**Re: Whataburger, 111 Coors Boulevard NW
Grading Plan and Drainage Plan
Engineer's Stamp Date 12-2-14 (K10D001B)**

Amy L. D. Niese, P.E.
Senior Engineer, Hydrology
Planning Department

GRADING AND
DRAINAGE PLAN

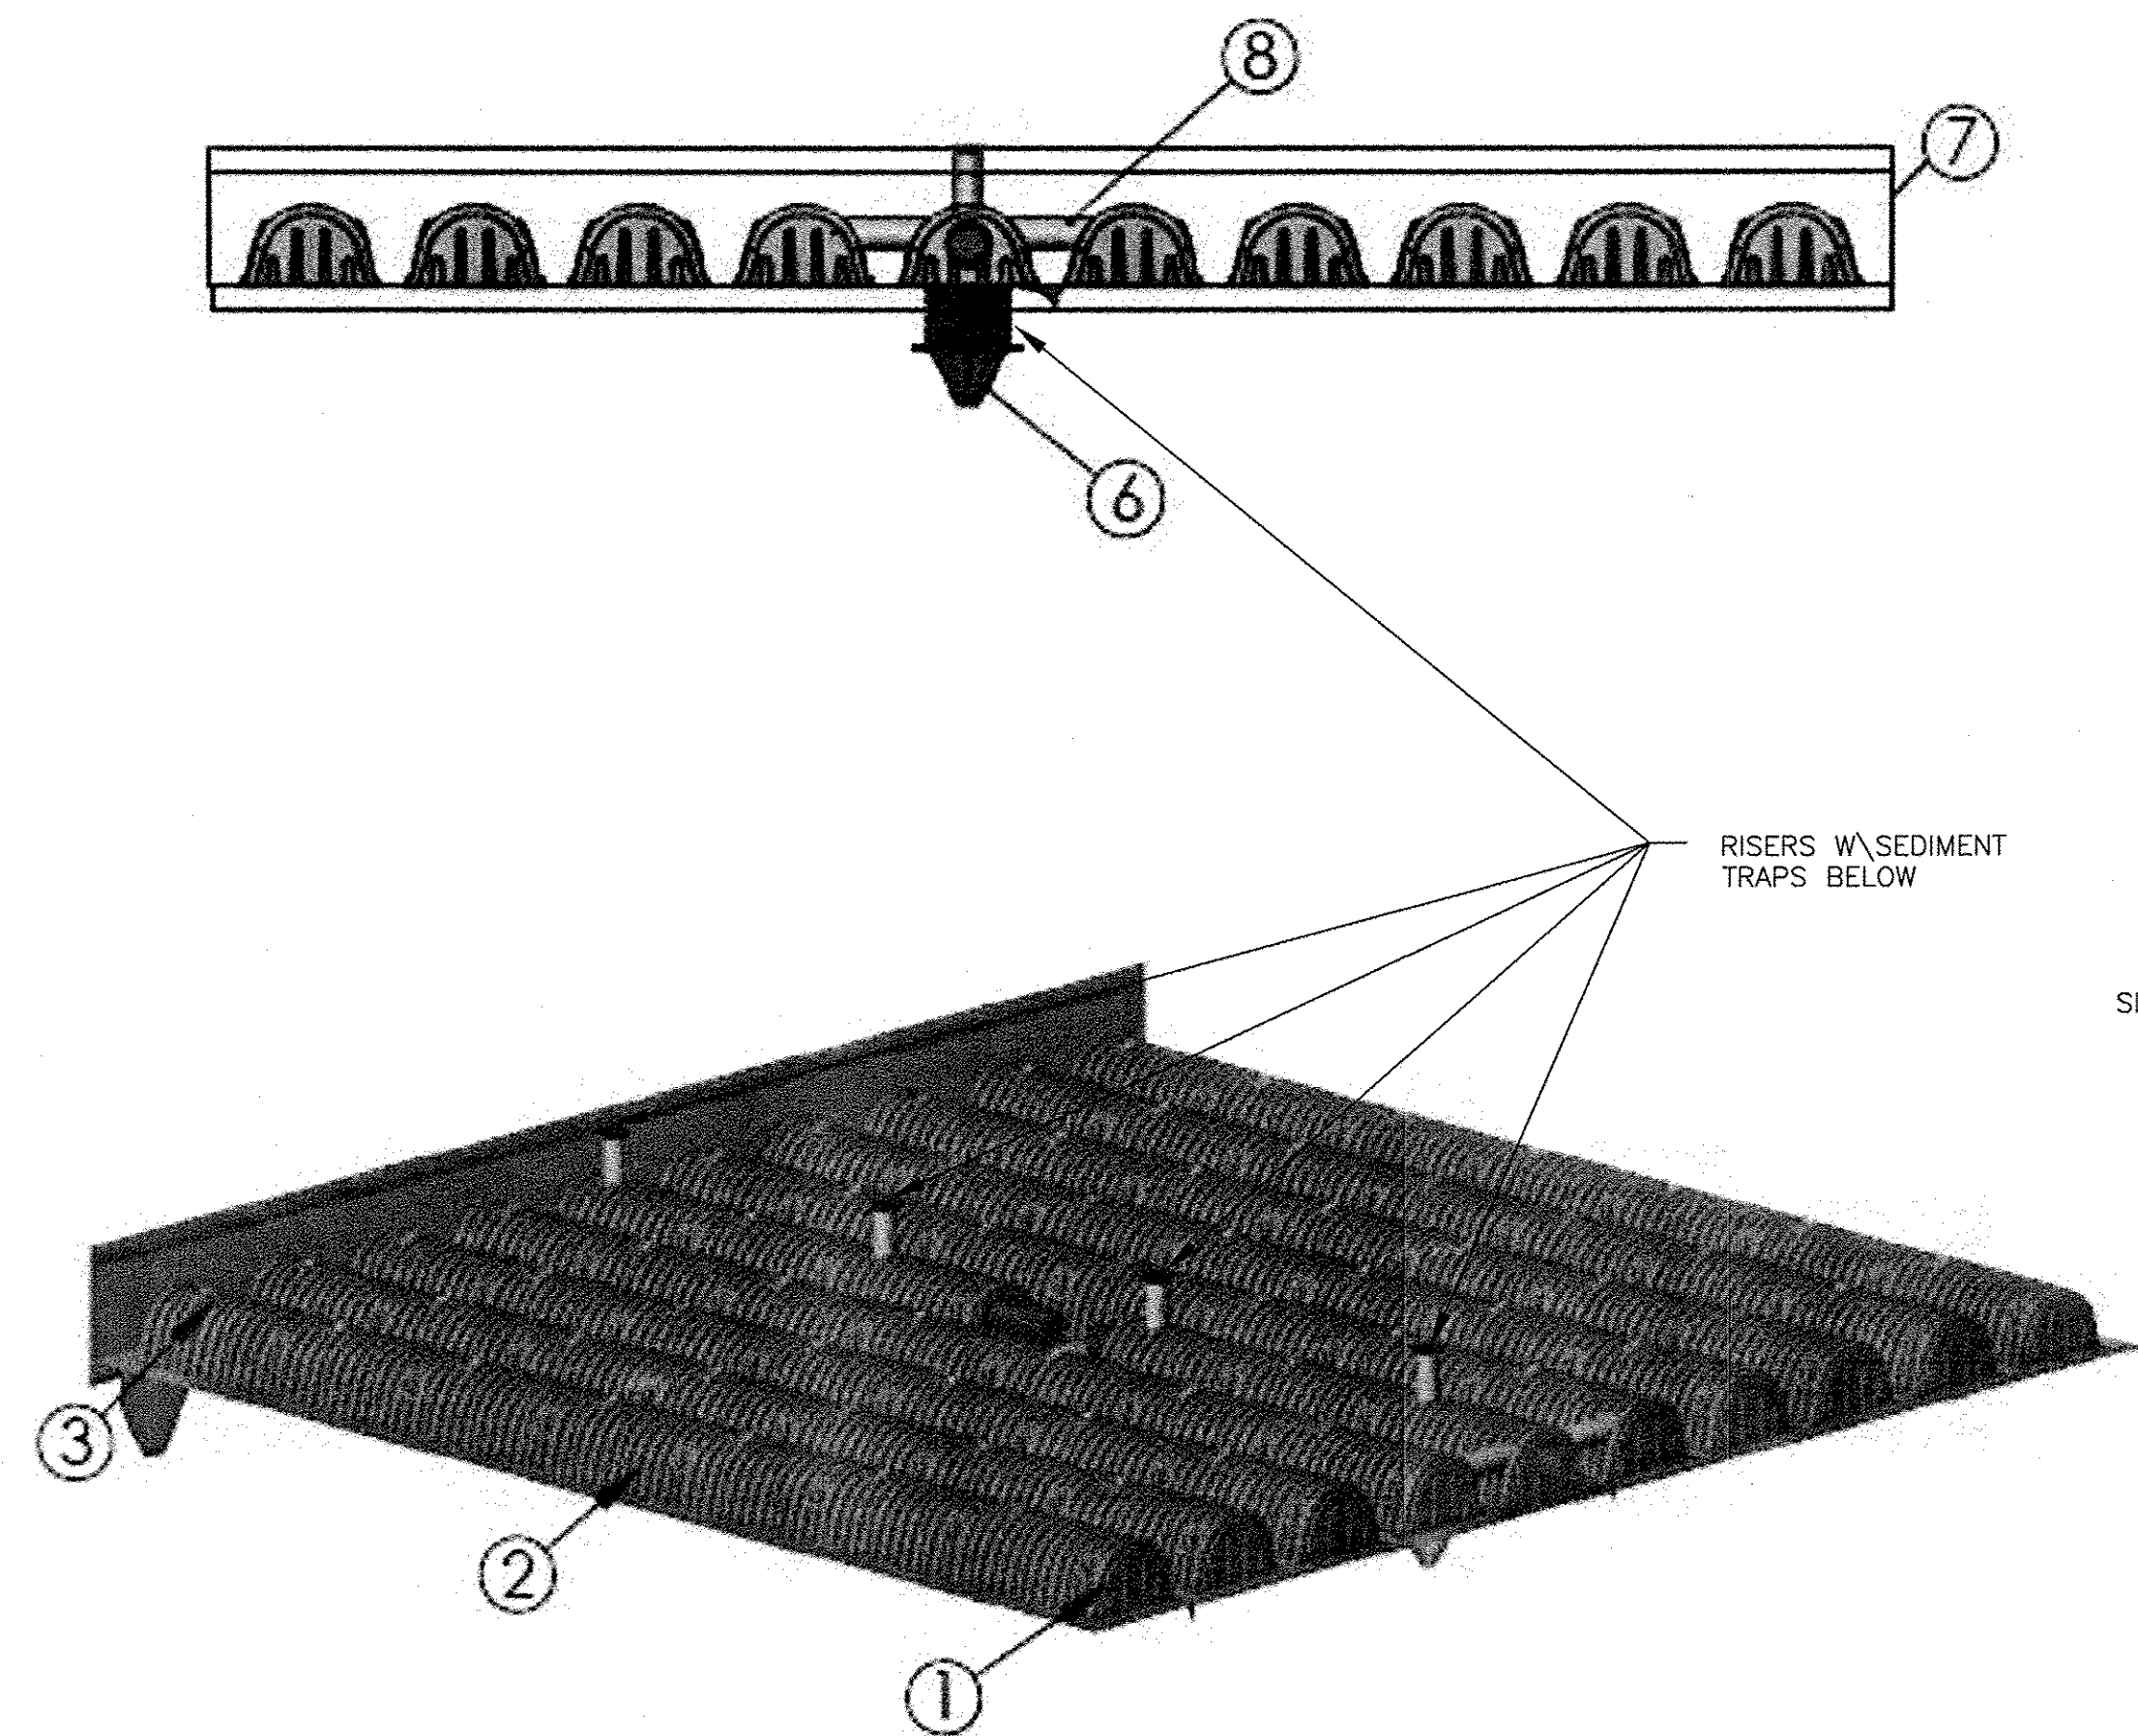
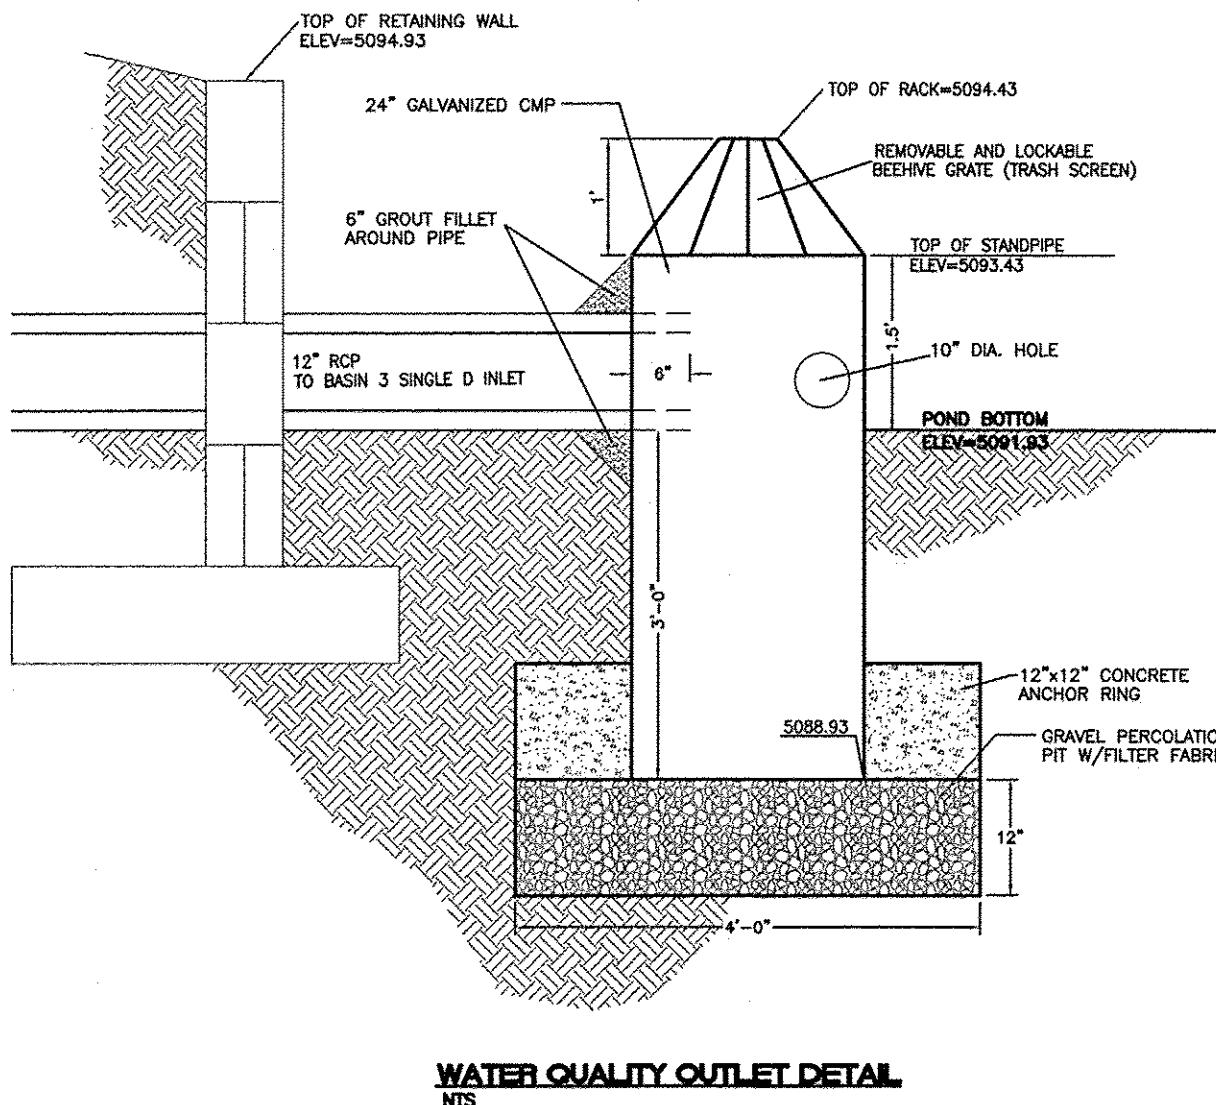
1. Identify the full extent of basins 4 and 5. Is the gas station to the north contributing flows? The basins on-site are defined by property lines instead of contour lines or spot elevations. Provide a basin map that includes the off-site basin and that contains sufficient information showing the basins defined by contour lines and spot elevations.

2. Is the two foot curb cut adequate for the off-site flows for Basin 5?
3. The First Flush is to be retained and discussed. Per the City Drainage ordinance, the 90th Percentile Storm Event, which is 44 inches, is to be managed. Reduce 0.44 inch by the 0.1 inch for the initial impervious abstraction in Table A-6 of Section 22 of the DPM. Multiply the remaining 0.34 inch by your impervious area. This is the portion to retain. Provide the amount that is necessary to be retained and how much is actually being retained. The Stormchamber could be utilized for retention if the invert out is raised to retain the First Flush. The north pond can also be used by raising the invert of the 10 inch hole in the water quality manhole. The landscaping on the west side can be utilized for retention by raising the inlet invert above the bottom of the pond.

5. For the water quality manhole are the inverts of the 24 inch RCP, 10 inch hole, and bottom of pond all at 91.93? If so, call out the inverts and show them that way. Show the top of the rack and the top of the retaining wall at the same elevation of 93.43 as they have been indicated. Is a water quality manhole really needed if a Stormchamber system being utilized? They seem redundant. Provide freeboard and a guardrail for the pond.

7. provide orifice calculations for 4 inch orifice in manhole 2.
8. Is the current lift station being removed? The proposed lift station seems very close to where the old one should have been.
